2023/0551

98 Upper Hoyland Road, Hoyland, Barnsley, S74 9NL

Two storey extension to rear of dwelling

first floor plan Scale: 1/50

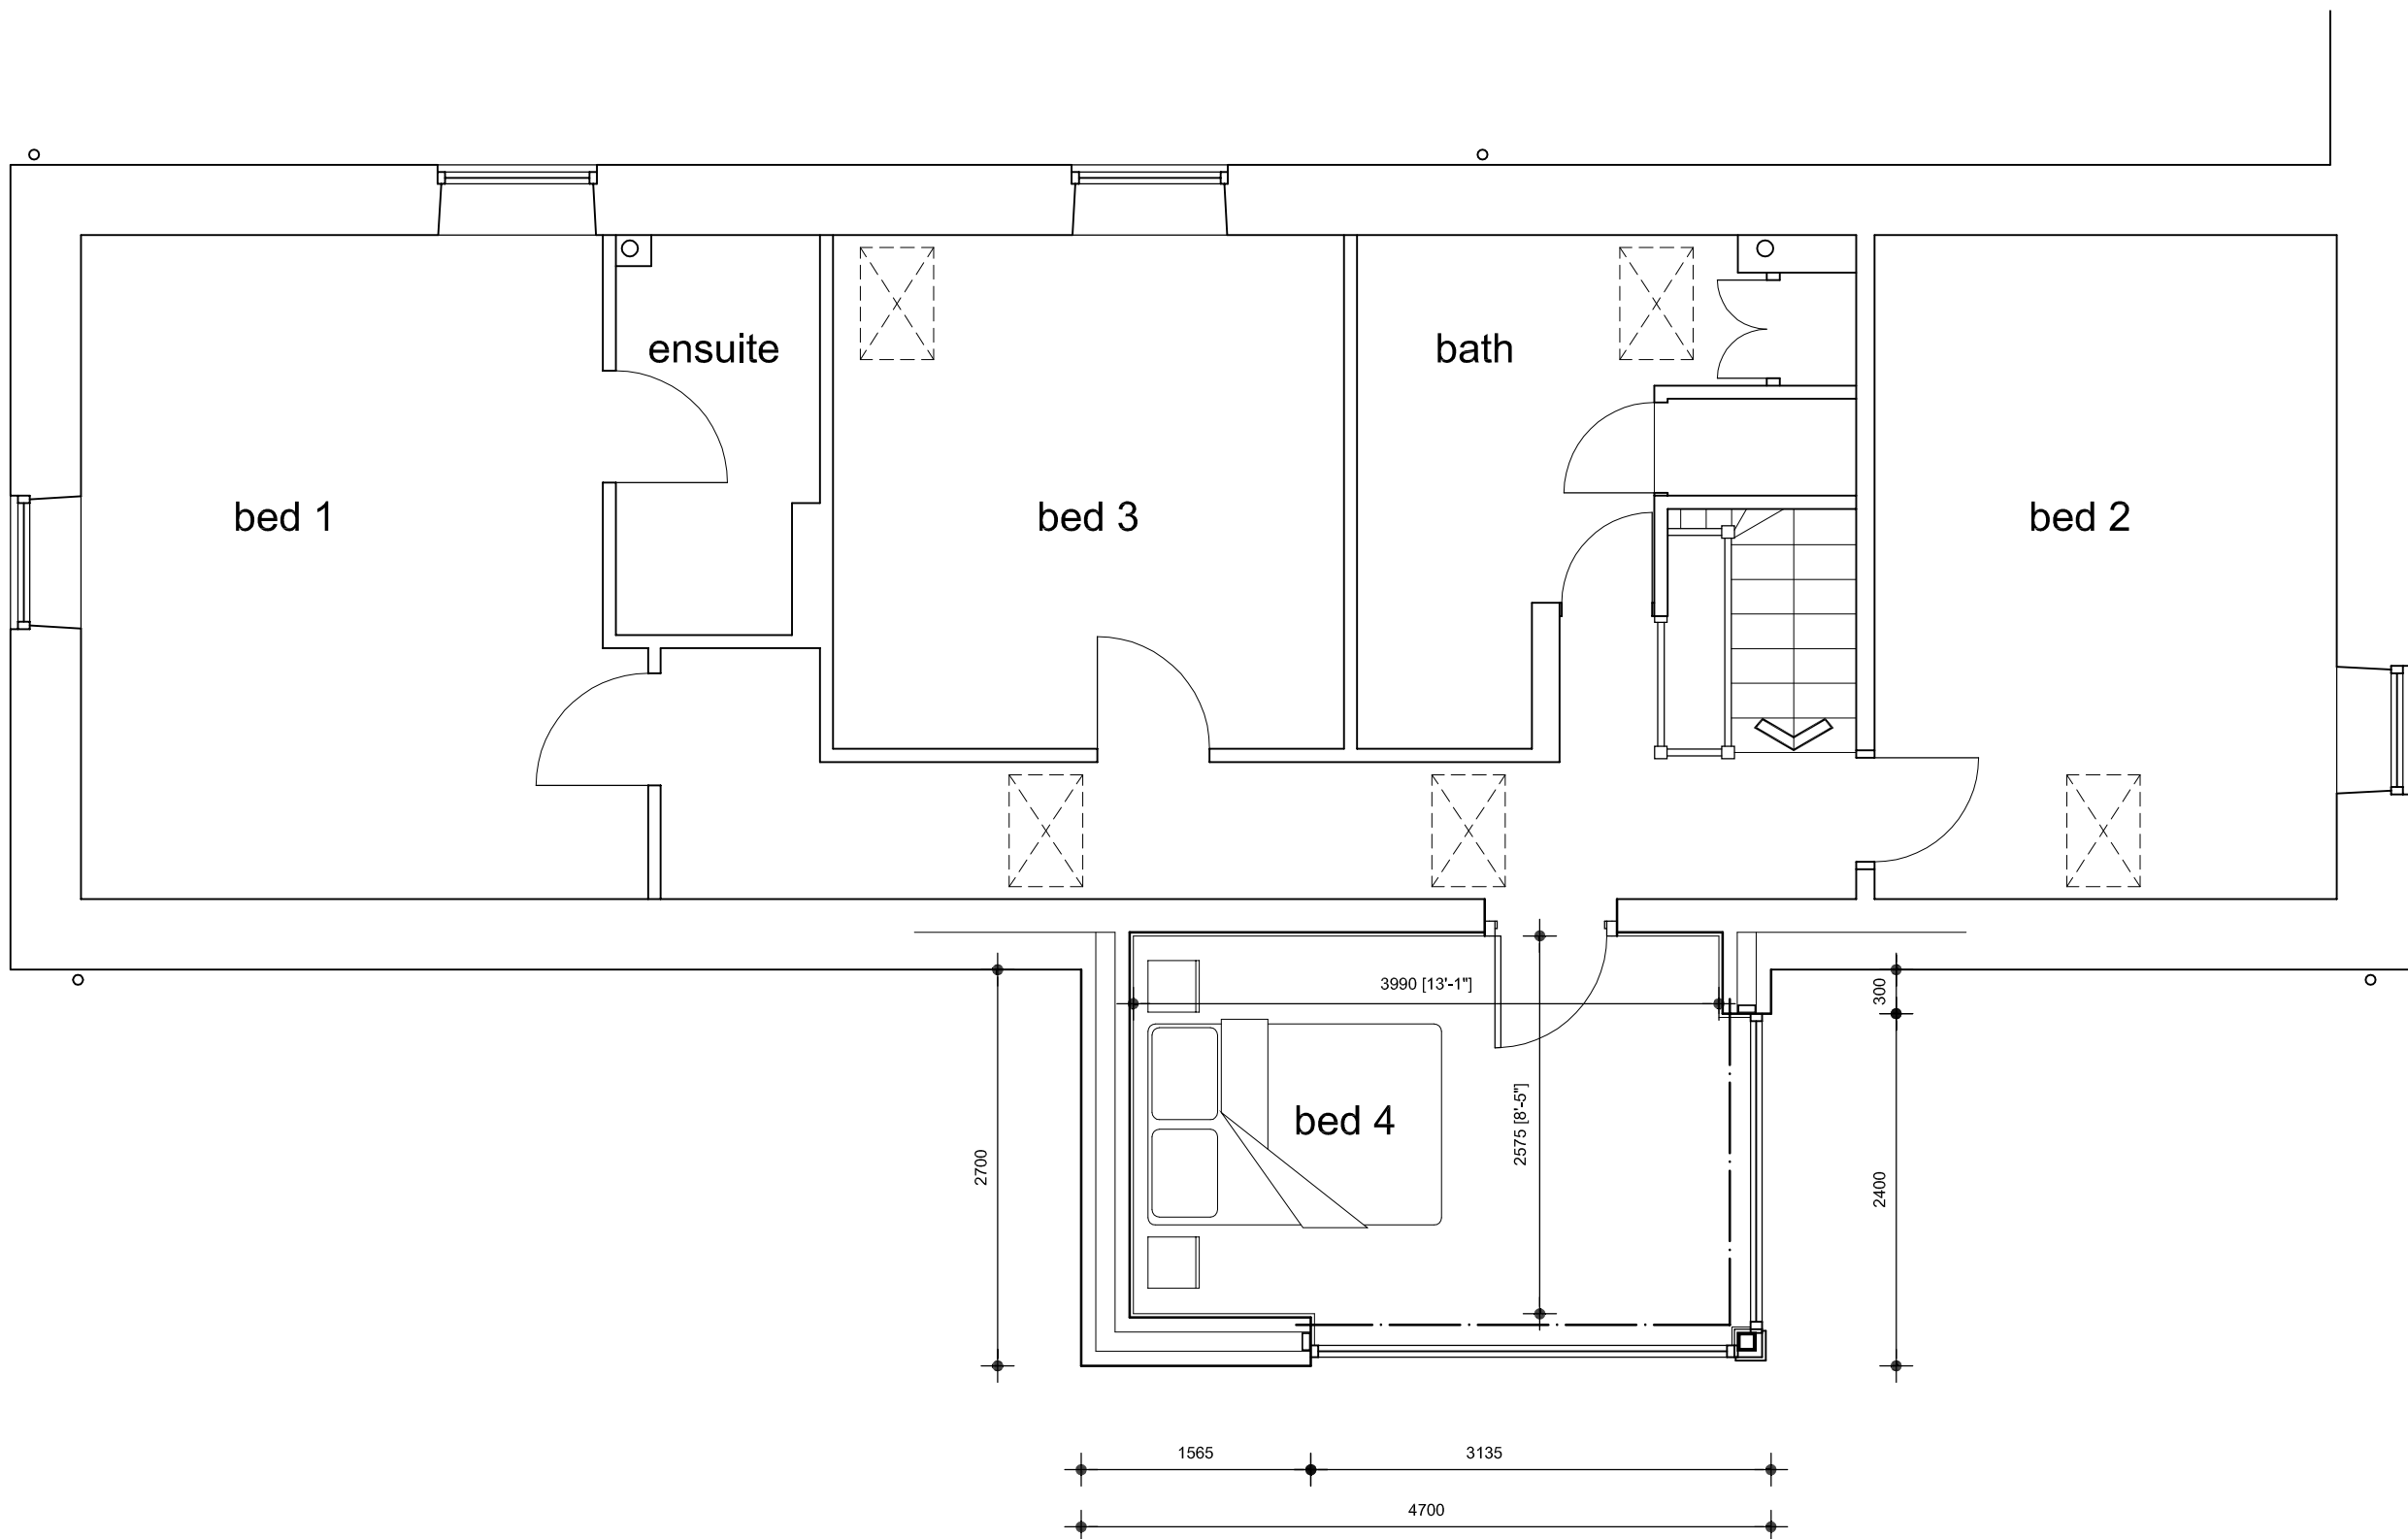
Amended proposals were received 18/07/2023 offering improvements, including a slight reduction in the total height of the extension, changes to external materials, and the inclusion of privacy glazing to some first-floor windows.

In this instance, the proposed extension would be of two-storeys and would maintain approximately 5.3 metres between the rear-facing first floor windows of the extension and the rear boundary. As such, the proposals would not meet the guidance of the SPD.

The windows located on the rear elevation of the proposed extension would face adjacent neighbouring property 100 Upper Hoyland Road. It is acknowledged that there could be some increased overlooking from the first-floor windows due to slight topography differences; however, due to the positioning of the applicant dwelling within the building line, views would generally be directed towards the side elevation of 100 Upper Hoyland Road where secondary windows are not offered the same protections as those serving habitable rooms on the front and rear elevations of the property. Some mitigation is likely to be offered from the screening created by existing projections, extensions, and outbuildings, and further mitigation would be offered by the proposals due to the inclusion of privacy glazing (level 5) to the first-floor rear-facing windows.

In this instance, the proposed extension would use external materials that partially matched those used in the construction of the main dwelling, including natural stone and grey concrete roof tiles. Other external materials to be used include grey powder coated aluminium panelling, doors, and windows. The proposed extension would also feature an apex roof that would reflect the style and pitch of the roof of the main dwelling.
